# City of Albuquerque Stormwater Construction Site Inspection Report

Project Name:	Del Webb Unit 3						
Location:	Tierra Pintada & Mirehaven Parkway						
Site Contact Name & Agency	Kevin Patton/Brian Anderson		ESC File No.	H09E017G			
	Pulte Homes		NPDES Id. No.	NMR100C1			
Inspection Date:	05/07/19	Start/End Time:	1000/1055hrs				
CoA Stormwater Inspector:	Timothy E. Sims						
Construction Phase:	perimeter wall and dry utilities						
Type of Inspection:	Regular	Storm Event	Post Storm Event >0.25"	311/Complaint	x	Follow Up

**ESC 108**

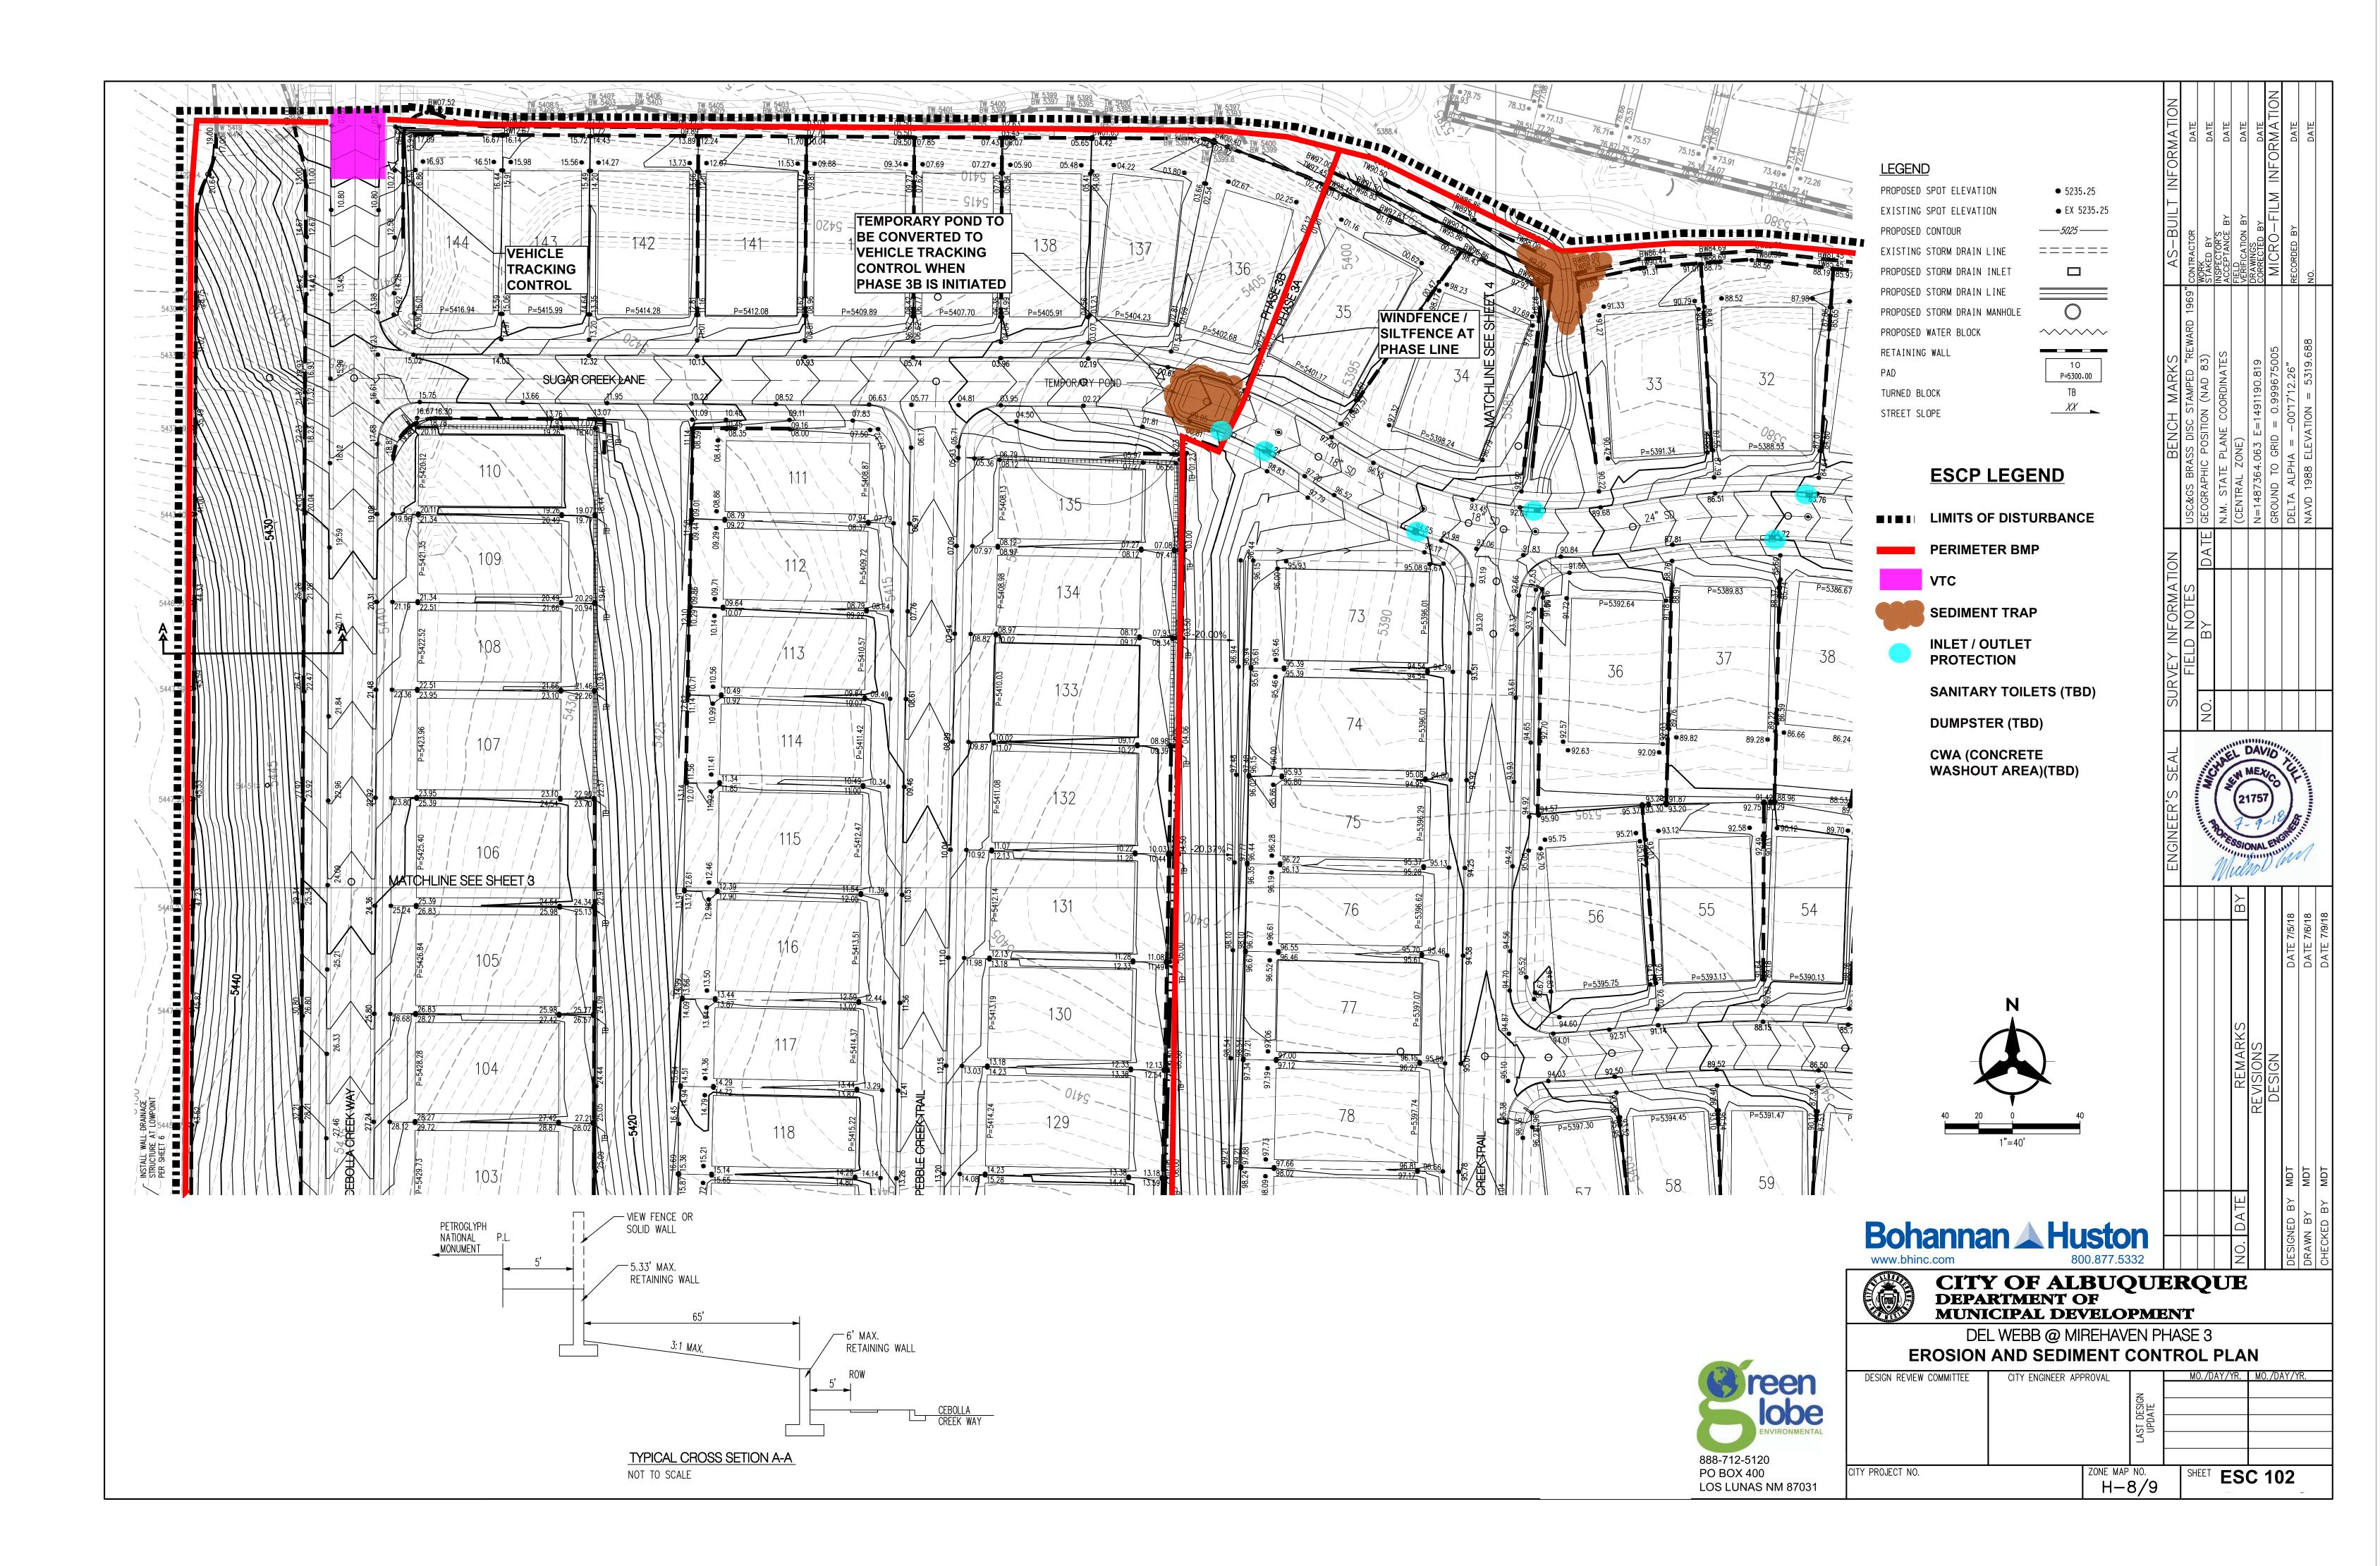
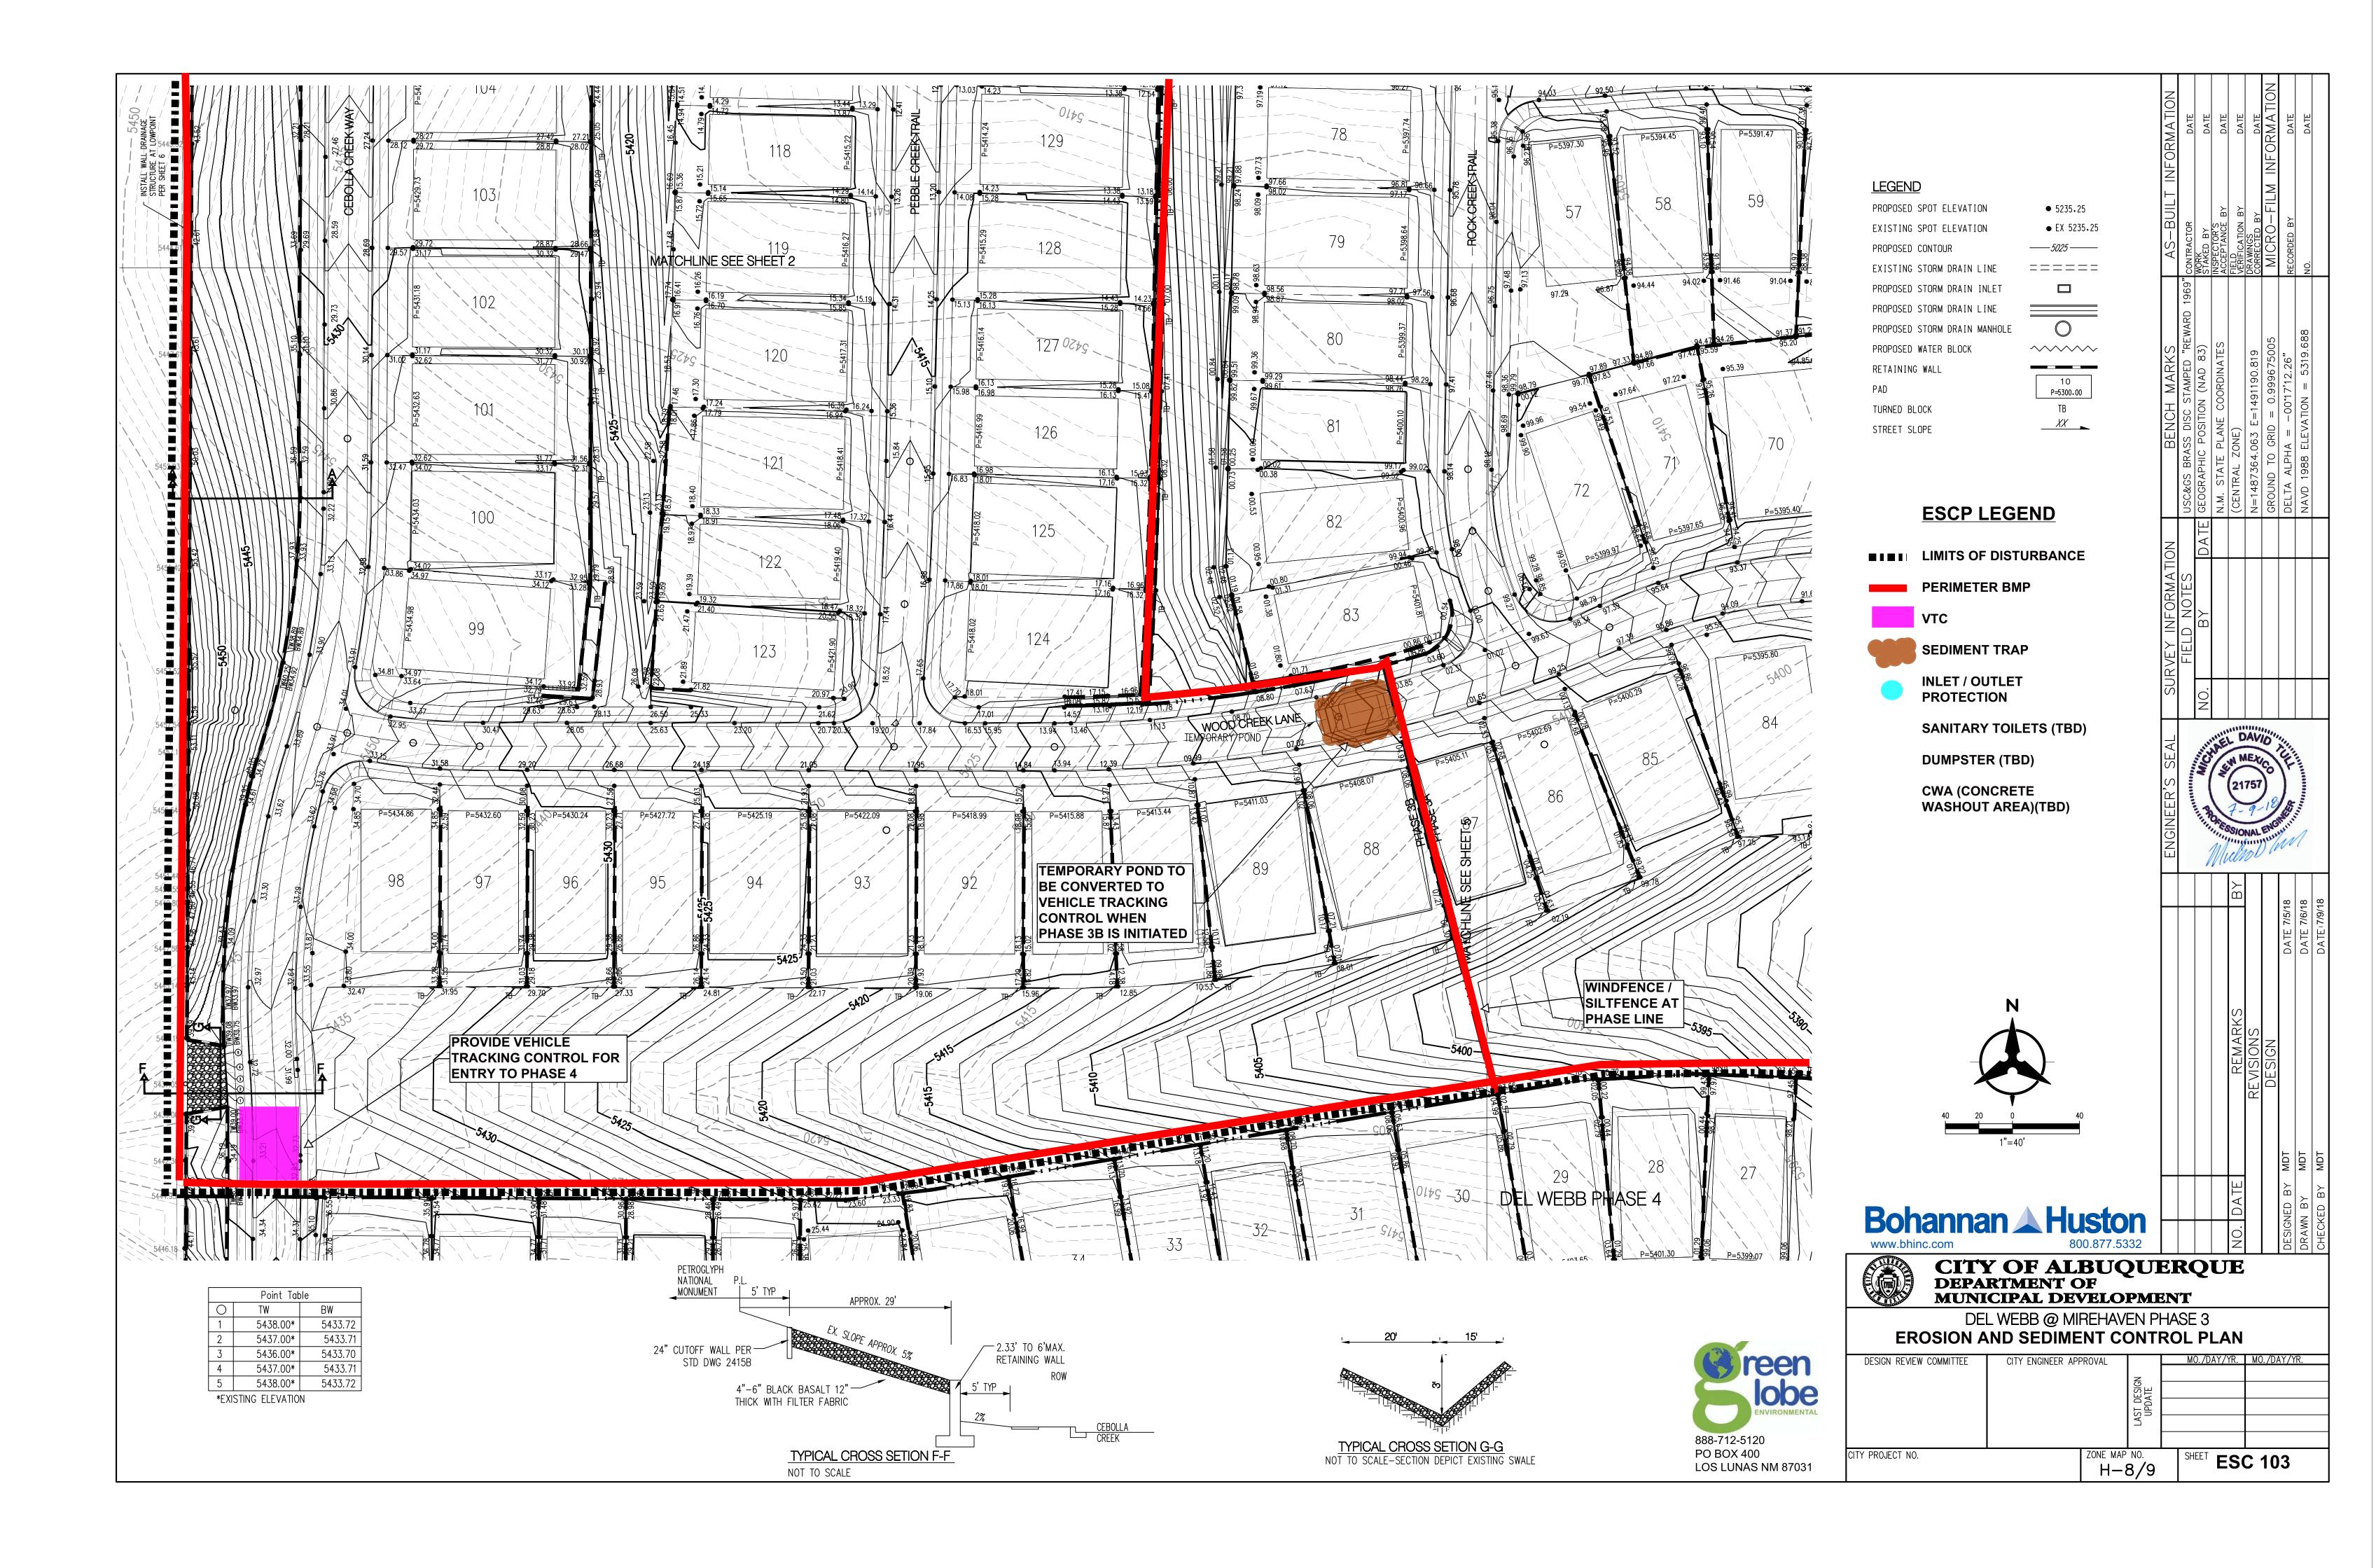
Item Number	Deficiency/ Corrective Action		
1	No pond NW corner - small unacceptable berm not compacted		
2	No pond or erosion control- North Street and next Street route		
3	No Inlet protection at storm drains - provide and clean		
4	no pond at storm drain location		
5	require silt fence SE corner of site.		
6	re-establish gravel at staging area within the SE corner.		
2.1	Discharge off site? (Y/N)	No	
4	Self Inspection Reports	requested	Latest report Date:
